29 January 2025

Jessica Watson
Senior Environmental Assessment Officer
Department of Planning, Housing and Infrastructure

State Significant Development - Pottinger Wind Farm - Major Project reference: SSD-59235464

Amber S10B

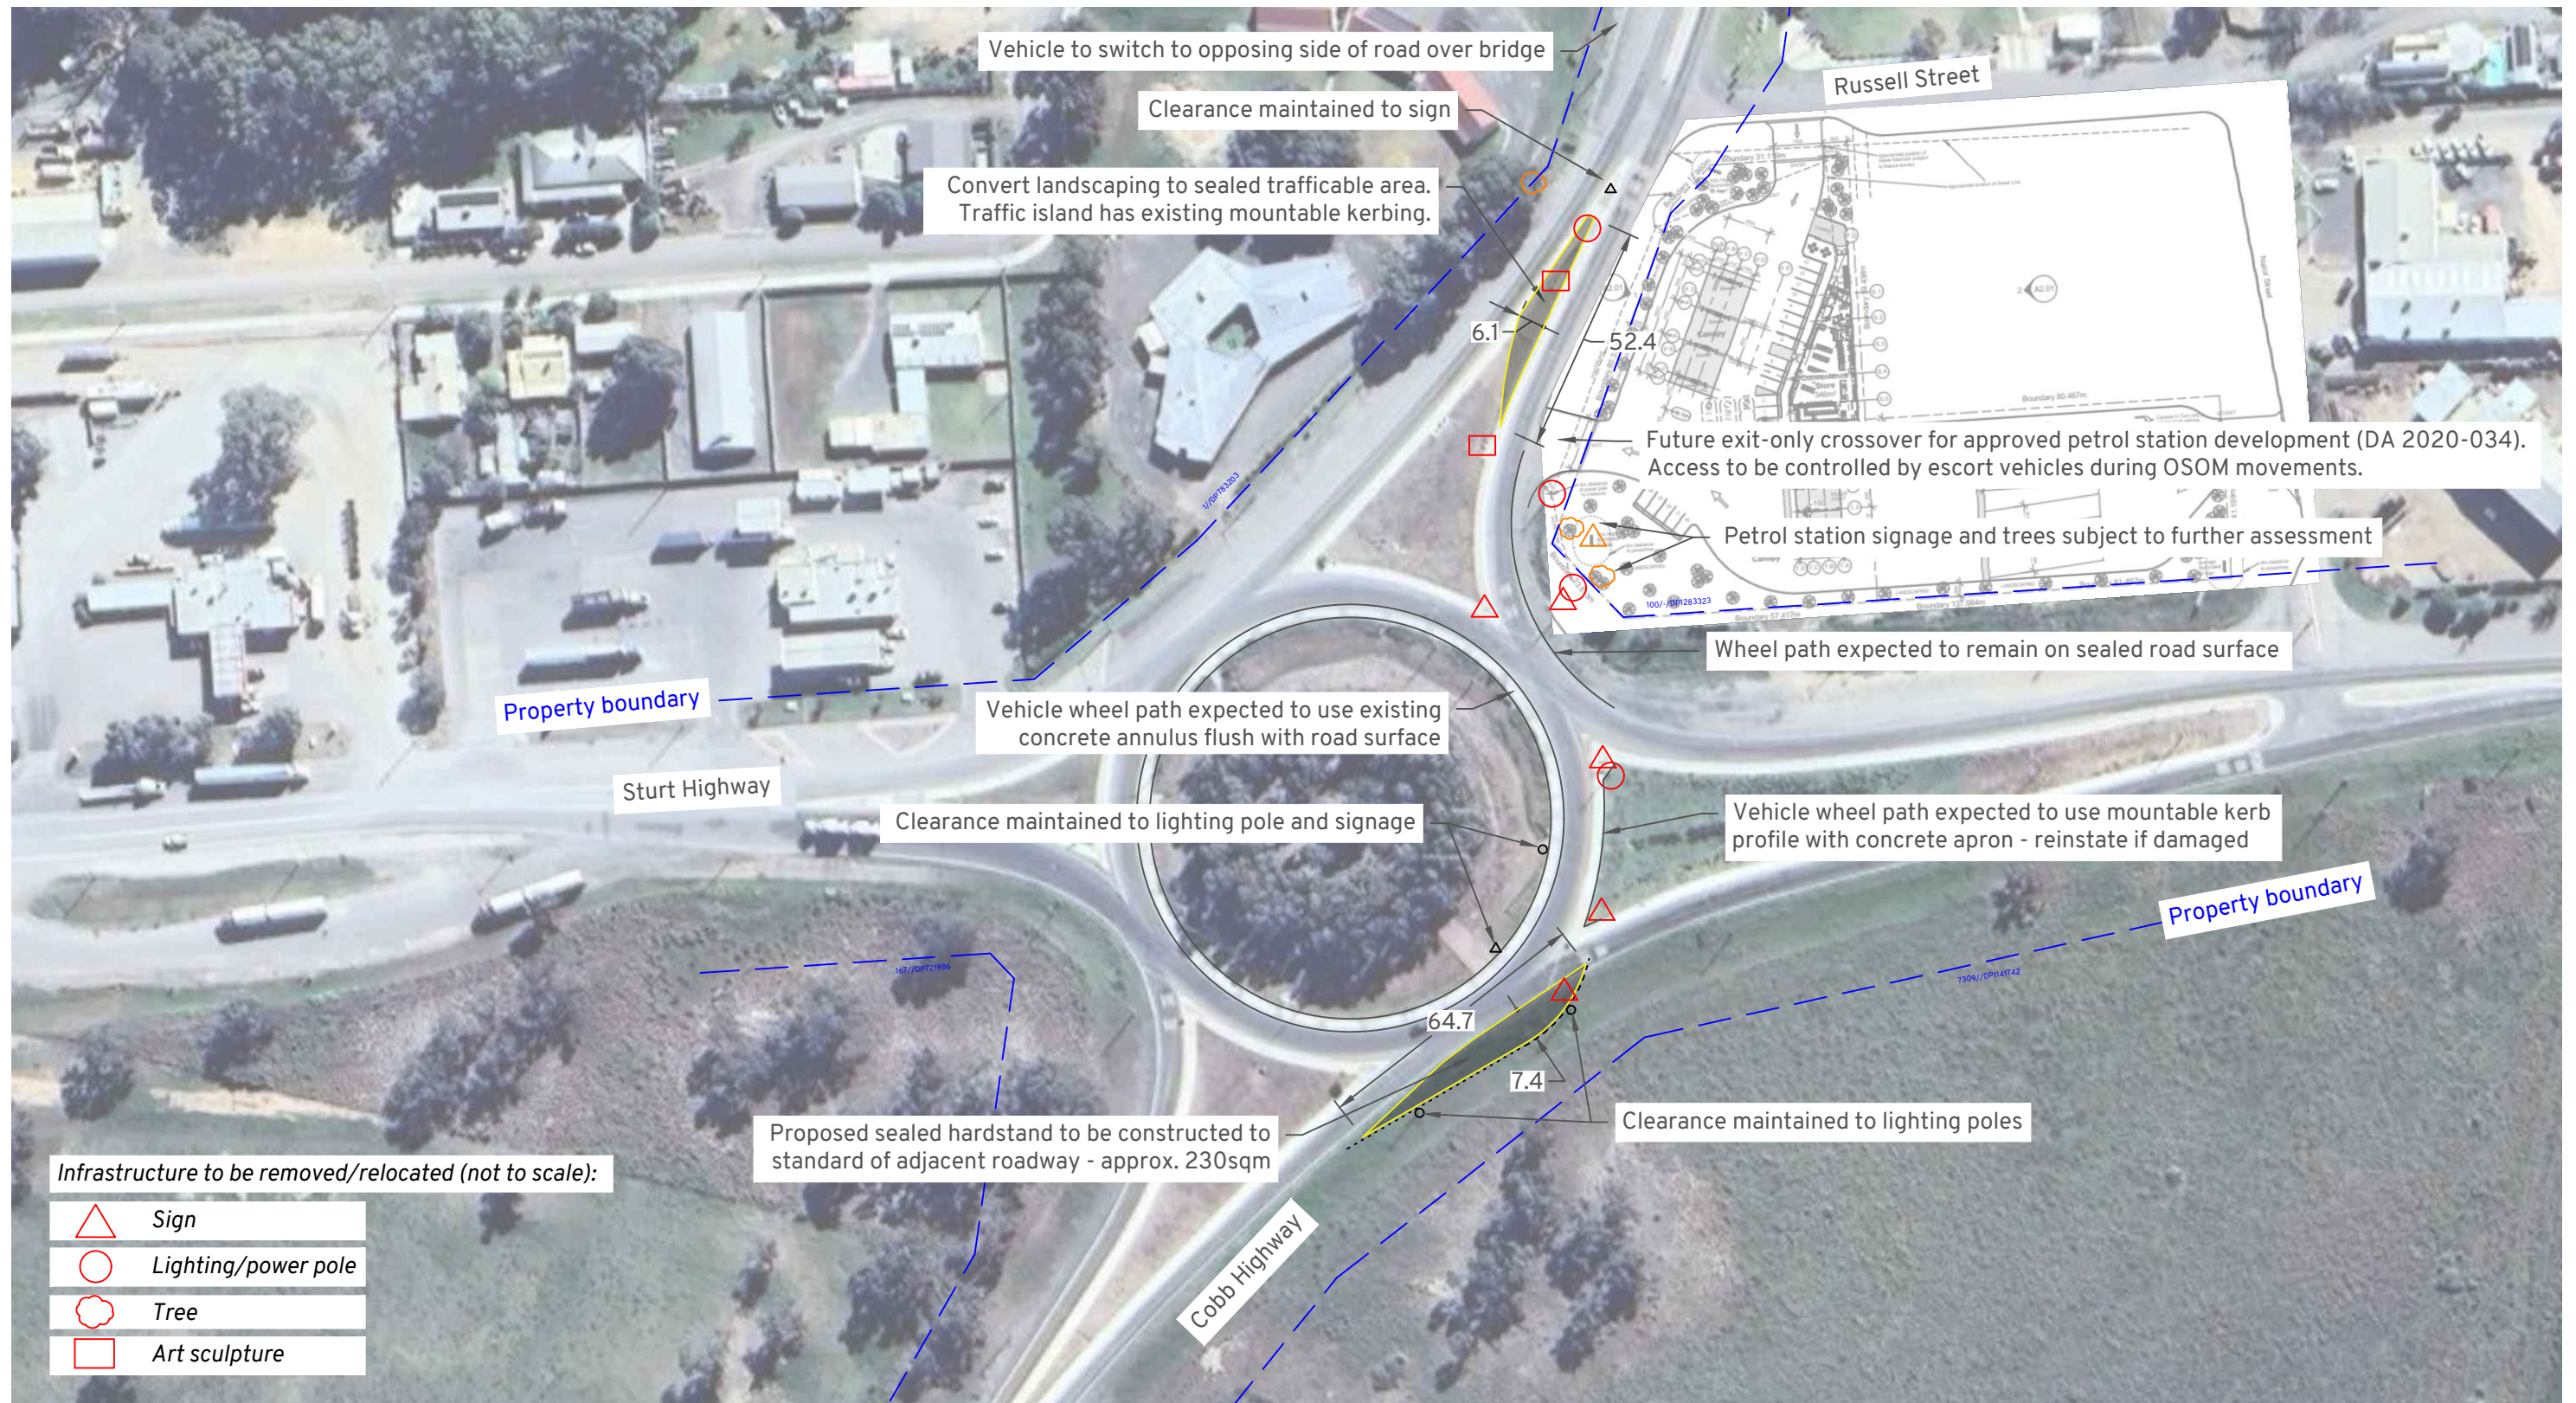
- It is noted that the transport route near the area of Sturt/Chettle Streets and Barrier Highway (Lot 7313) requires fencing to be re-aligned and new gate installed. It appears that this area may cut through a Mining Lease, of which Perilya Pty Ltd has an interest in ("Broken Hill North Mine"). Council suggests that the consent Perilya be sought prior to DA consent being issued.
